Banovallum House  
Manor House Street  
Horncastle  
LN9 5HF

## RESPONSE TO FOSSE GREEN ENERGY – EXAMINATION STAGE (DEADLINE 2)

Bird Mitigation Land Allocation

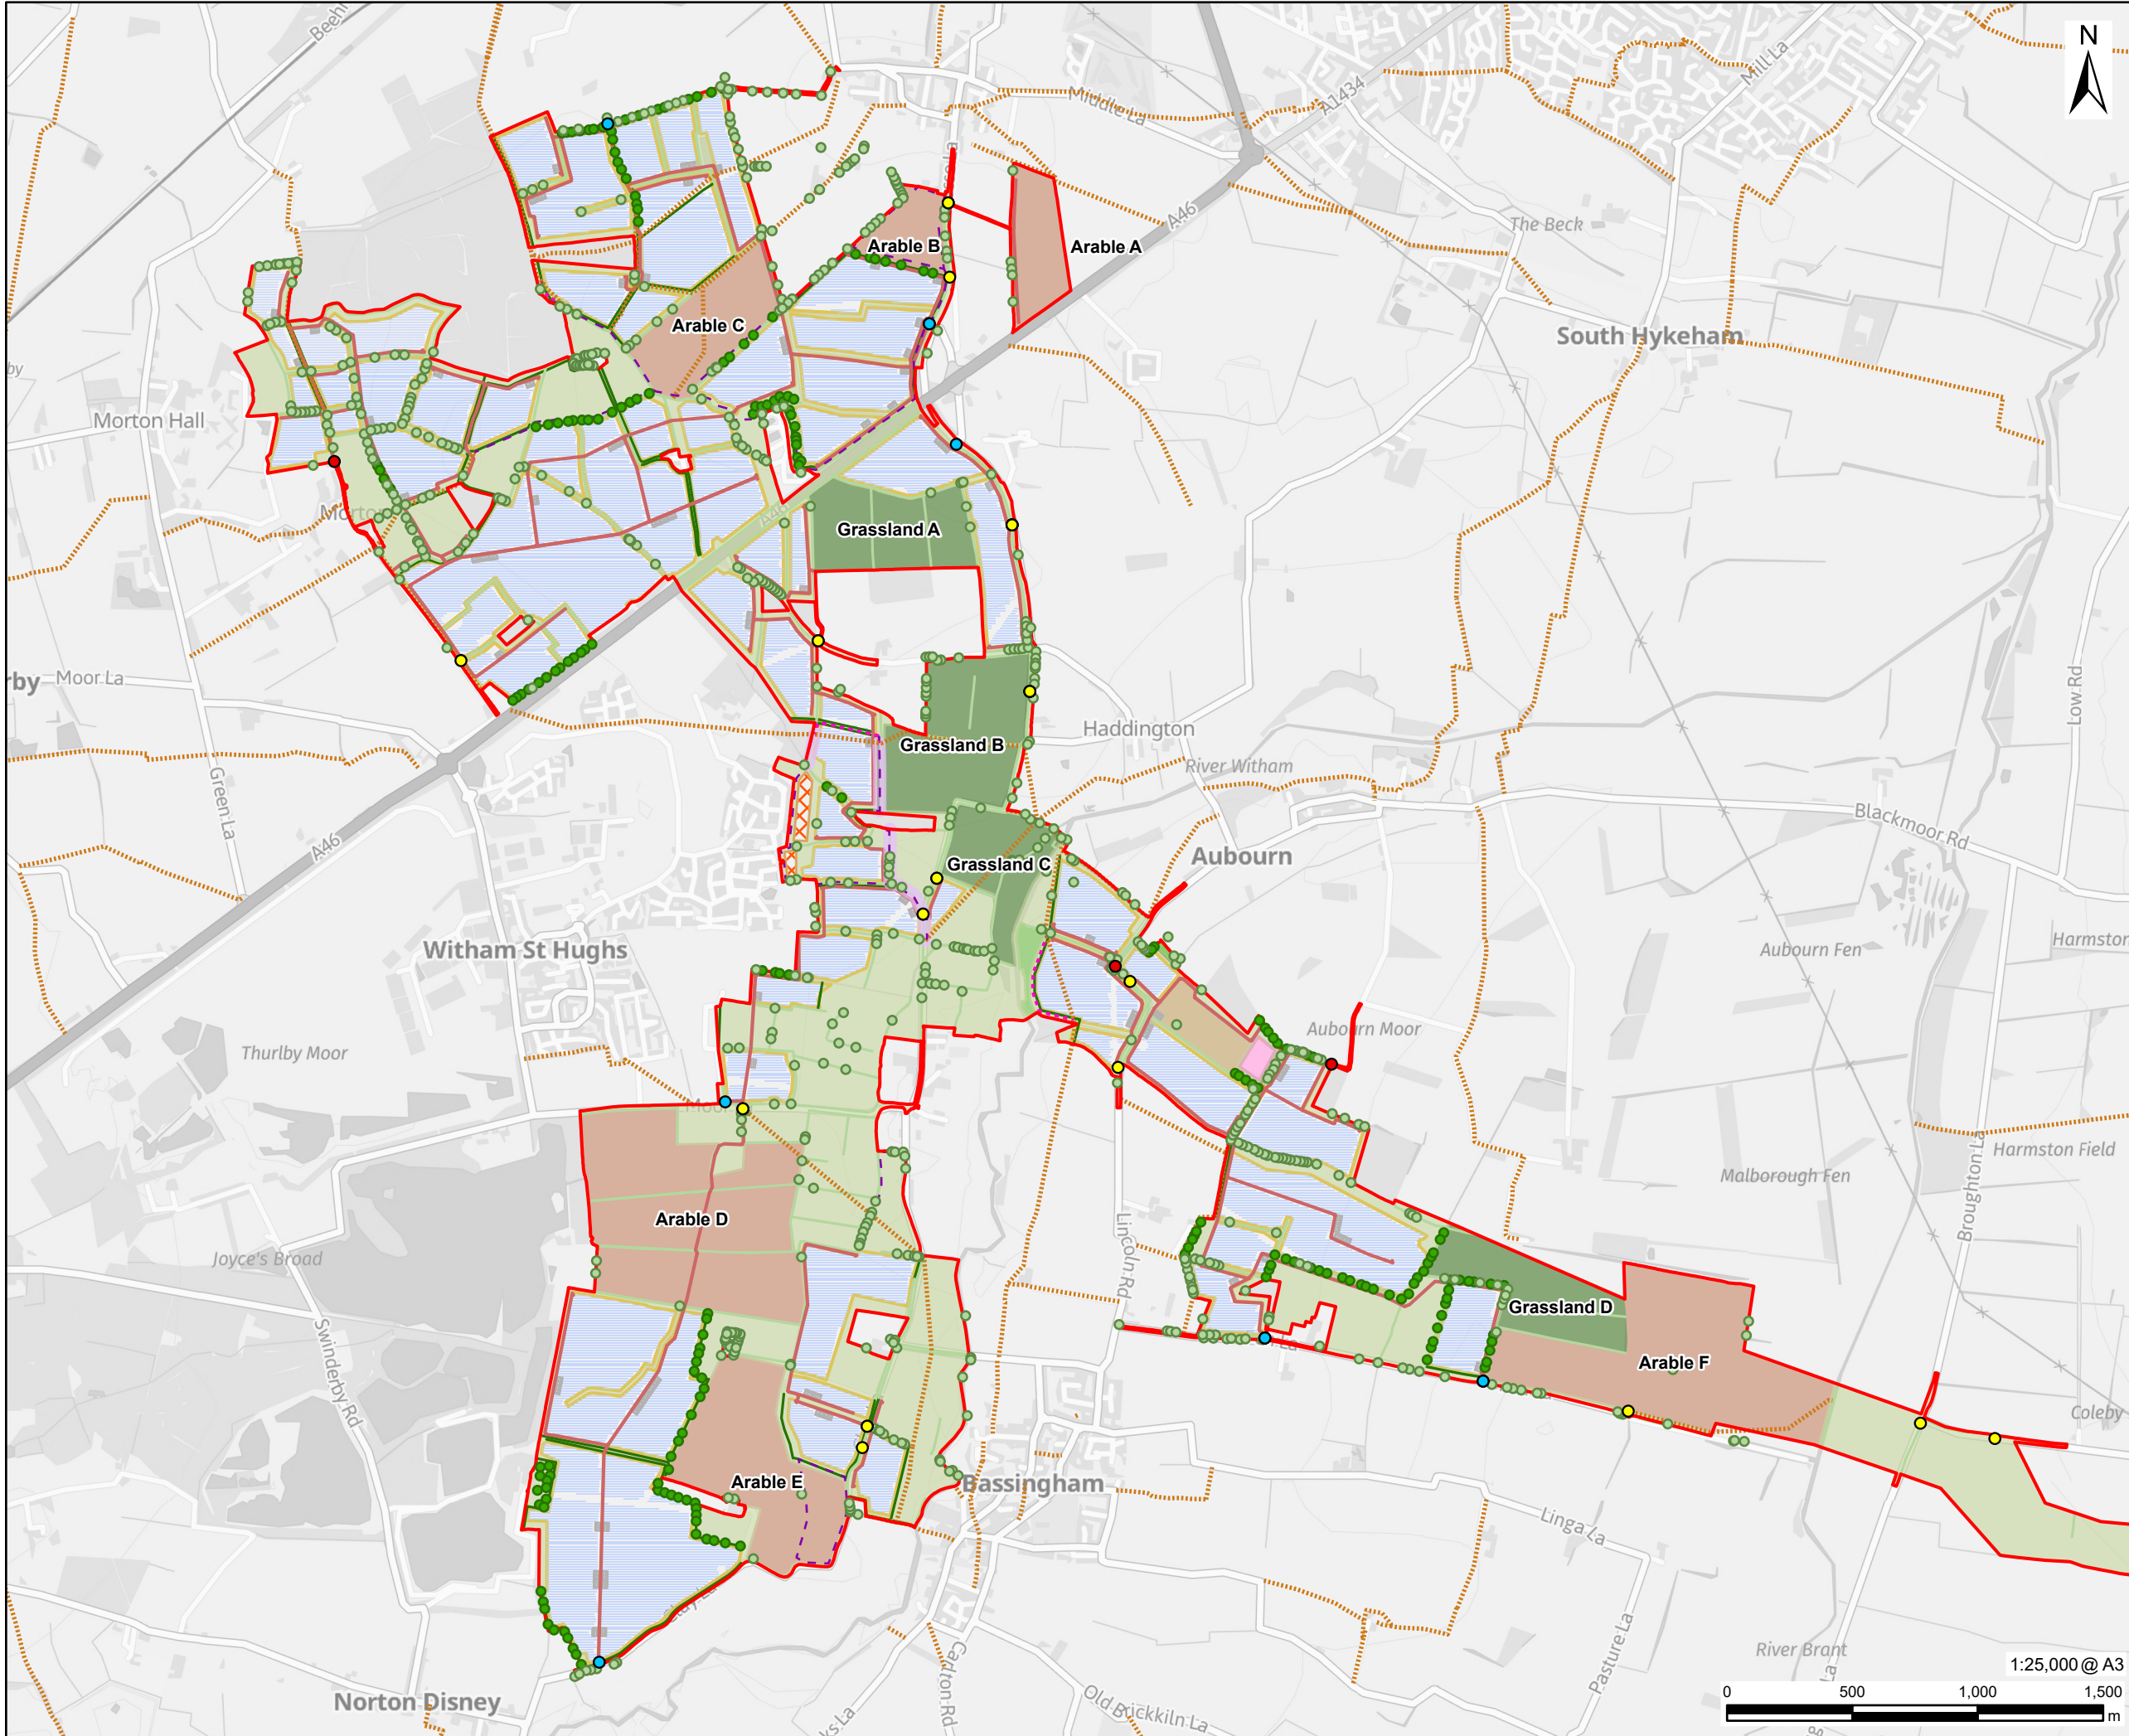
We have one outstanding query on this topic. Table 8-13 of ES Chapter 8 (Revision 2) states, in reference to areas to be managed restrictively for the provision of ground-nesting birds:

*“These areas, will provide extensive benefits for other IEFs and wider biodiversity and include 64ha of permanent grassland and 181ha of managed arable”*

Meanwhile, Section 4.2.4 of the Framework Landscape and Ecological Management Plan (FLEMP) (Revision 4, 20<sup>th</sup> January 2026), states:

*“Approximately 83ha of permanent grassland [will be created] for bird mitigation purposes”.*

Clarification on this discrepancy in the reported hectares of permanent grassland is required.
